Please ask for: Mrs D Johnson
Email: daun.johnson@arun.gov.uk
Telephone: 01903 737762
Our Ref: FP/51/21/PL
Your Ref:
Date: 11th March 2021

Application for Planning Permission

Development: Demolition & erection of 1 No. dwelling with associated works. This site is in CIL Zone 4 & is CIL Liable as new dwelling.
Location: 32 Sea Drive Felpham PO22 7NE

Project	Felpham House		
Title	Front & Rear Elevations		
Date	26.02.21	Drawn by	fm
Scale	1:50 @ A1	Drawing no.	7013/16
		Rev.

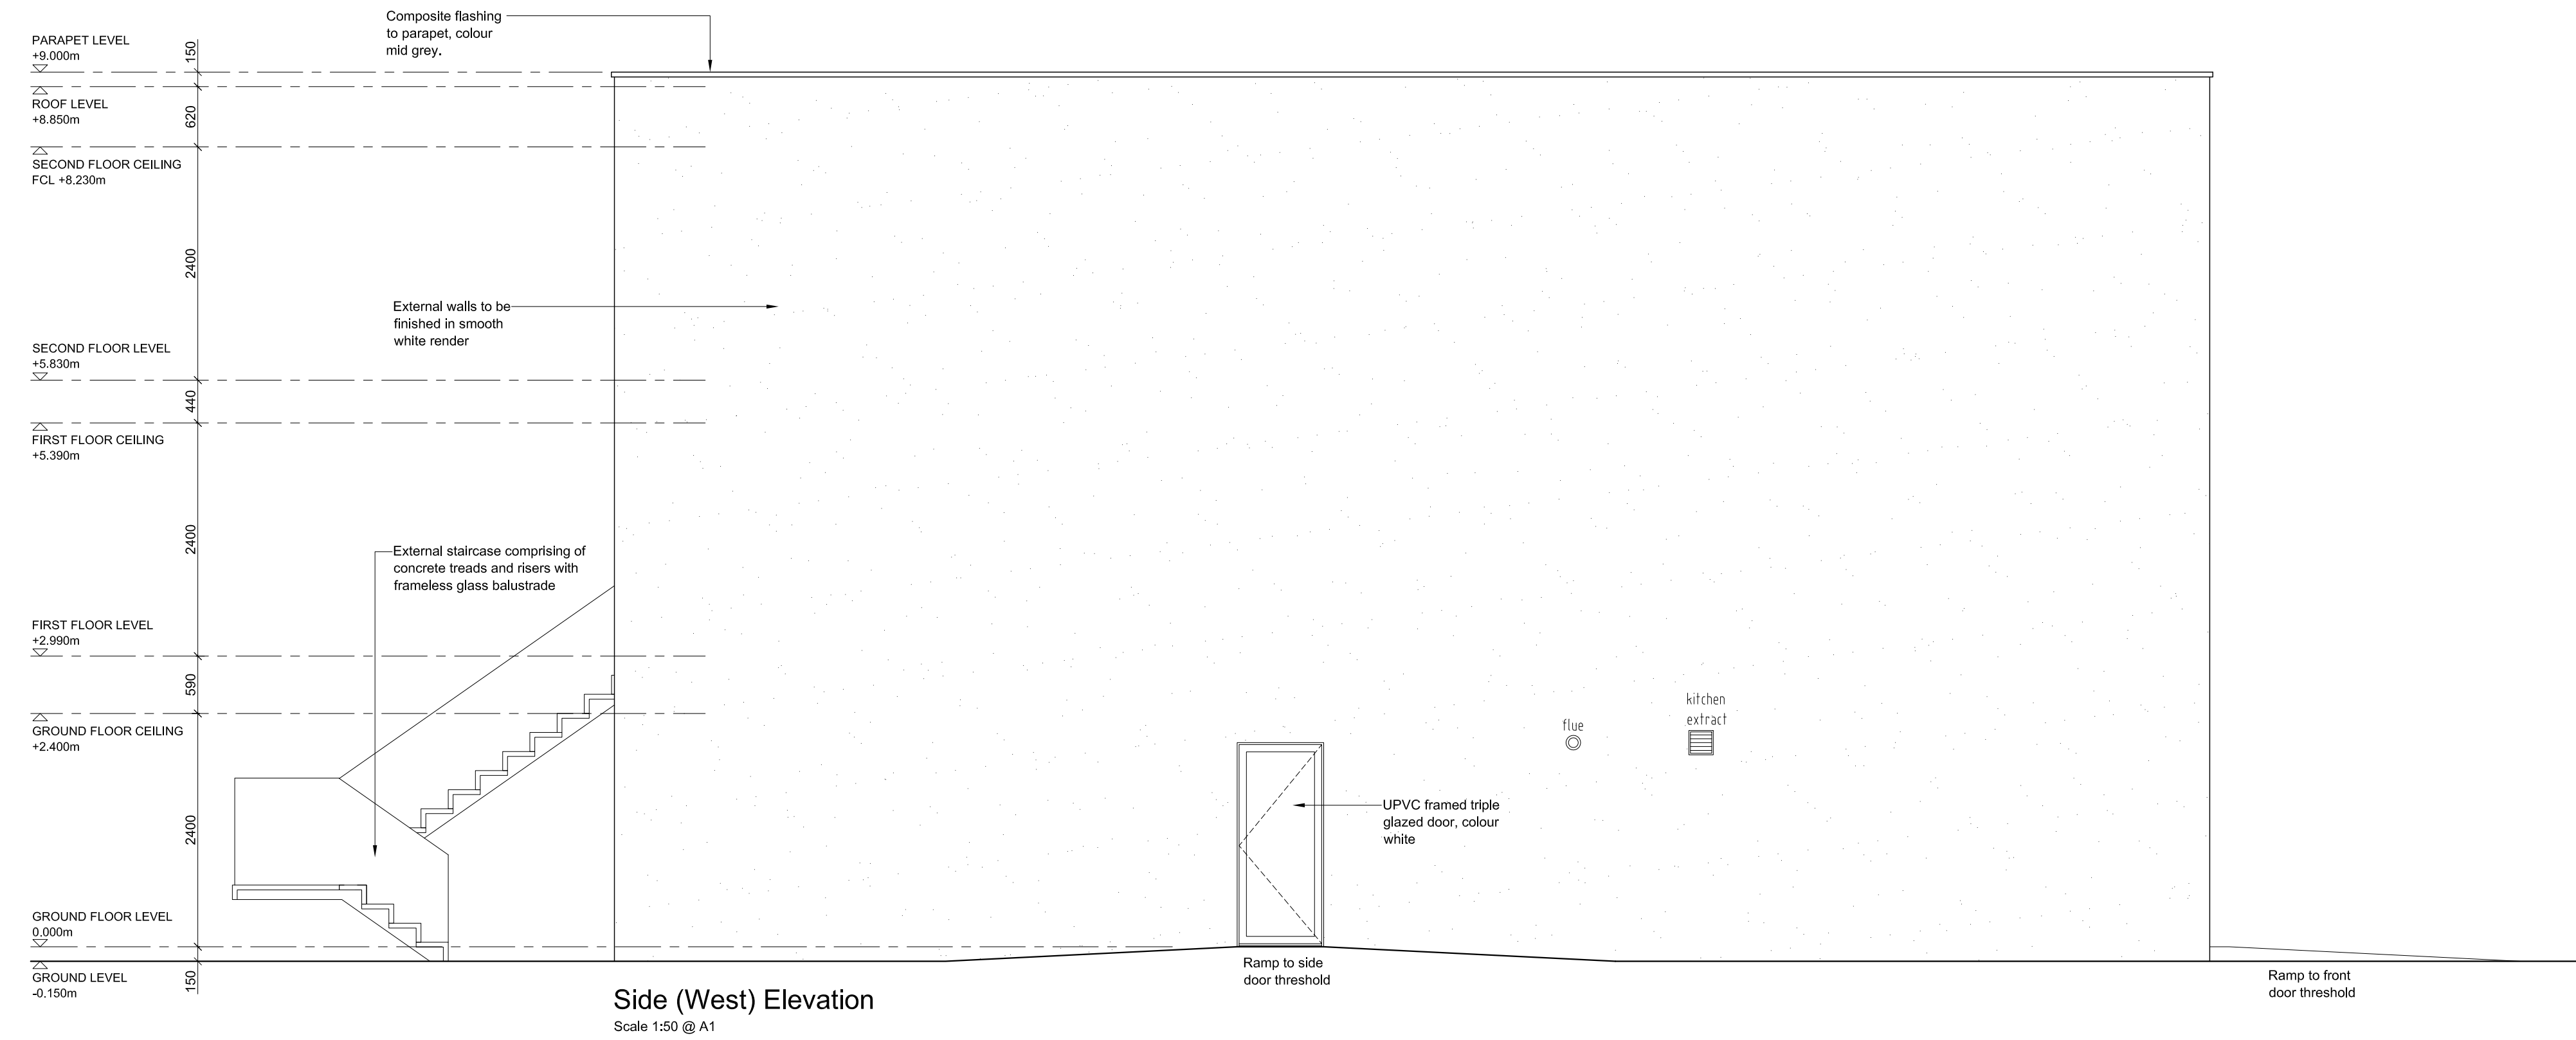
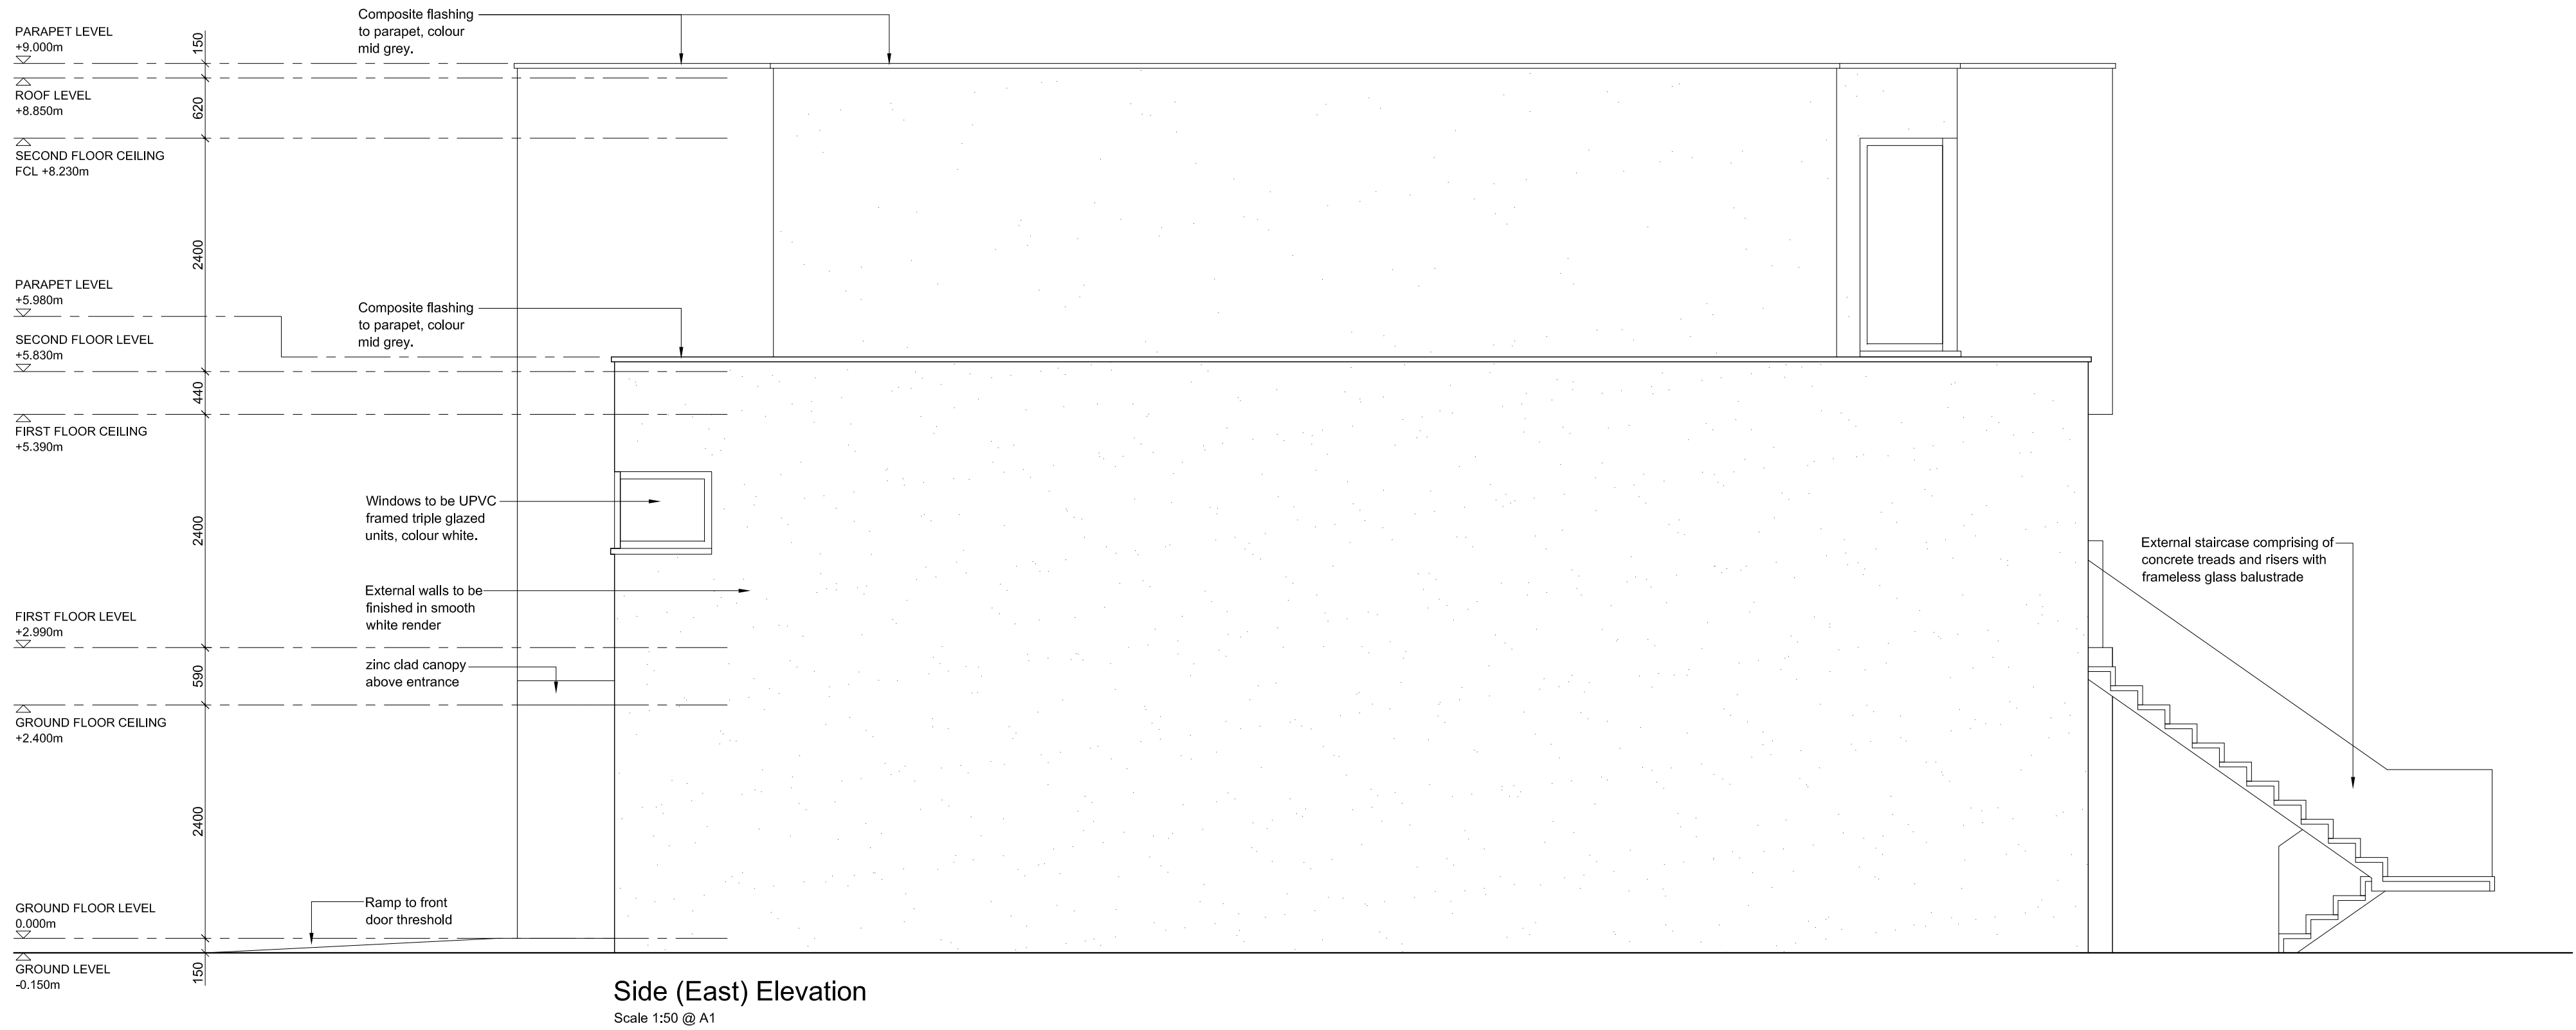
The proposed east and west elevations have been mislabelled. Please amend accordingly.

On plan 7013/16 the legend has been mislabelled. Please amend accordingly.
